Head of Planning and Development Consultation Response from KC, Conservation and Design
2019/94083 The Warehouse, 12, Zetland Street, Huddersfield, HD1 2RA
Advertisement Consent for installation of 7 illuminated and non-illuminated signs (within a Conservation Area)
Date Responded: 15.01.20 Responding Officer: Sue Oakley Responding Ref:

STONEGATE - WAREHOUSE - EXISTING & PROPOSED ELEVATIONS - Scale 1:100

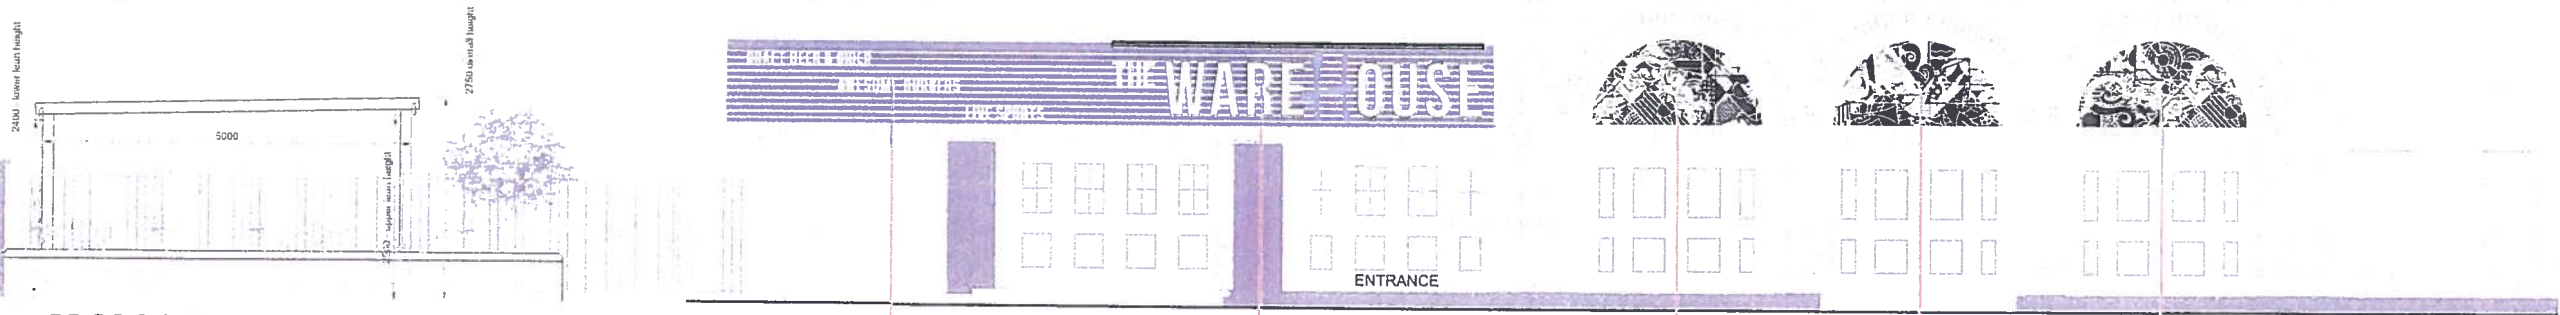
Item 5 – 2m high mild steel blue cut out mannequin with a neon outline and applied plaques. The application states that this is 2m high from ground level although it appears from the proposal image that it is set onto a low brick wall on the site boundary.

I have no objections to the proposed signage 1 to 4 as I do not consider them to harm the character of the conservation area or the setting of the surrounding listed buildings. I have concerns about the proposed neon outline mannequin as this area is already cluttered with street furniture and I would consider this to add to the clutter and harm the character of the conservation area. I would prefer this to be omitted from the proposal.
